Rezoning Transportation Analysis

Petition Number: #2022-078

Revision Log:

Date	Description
11-02-22	First Review (TM)
01-25-23	Second Review (TM)
02-28-23	Third Review (DR)

SHEET NUMBER **RZ-02**

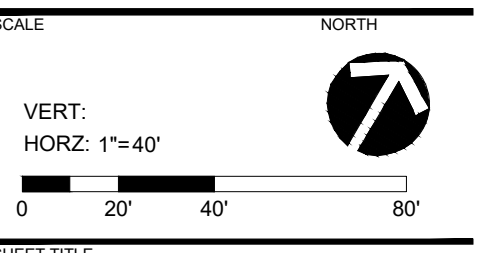
1. ~~**Curbline:** The proposed zoning district has a setback measured from back of the existing or proposed future curbline.~~
 - a. ~~**West Trade Street:** The future location of curb and gutter is measured at 17.5 feet from the centerline of the roadway to the BOC.~~

~~Label and dimension the curb and gutter from the centerline for each road on the site plan.~~

3. ~~Revise site plan and conditional note(s) to commit to constructing the proposed internal private roadways to private road standard typical section standard per CLDSM 11.13. Site plan shall dimension from the centerline of the roadway and callout roadway typical per CLDSM. Add a conditional note committing to constructing all private streets to the standard of CLDSM 11.13.~~

4. ~~Revise site plan to commit to construct an 8-foot planting strip and 8-foot sidewalk along the site frontage per Chapter 19. The site plan shall label and dimension both items from the back of future curb and gutter and road centerline.~~
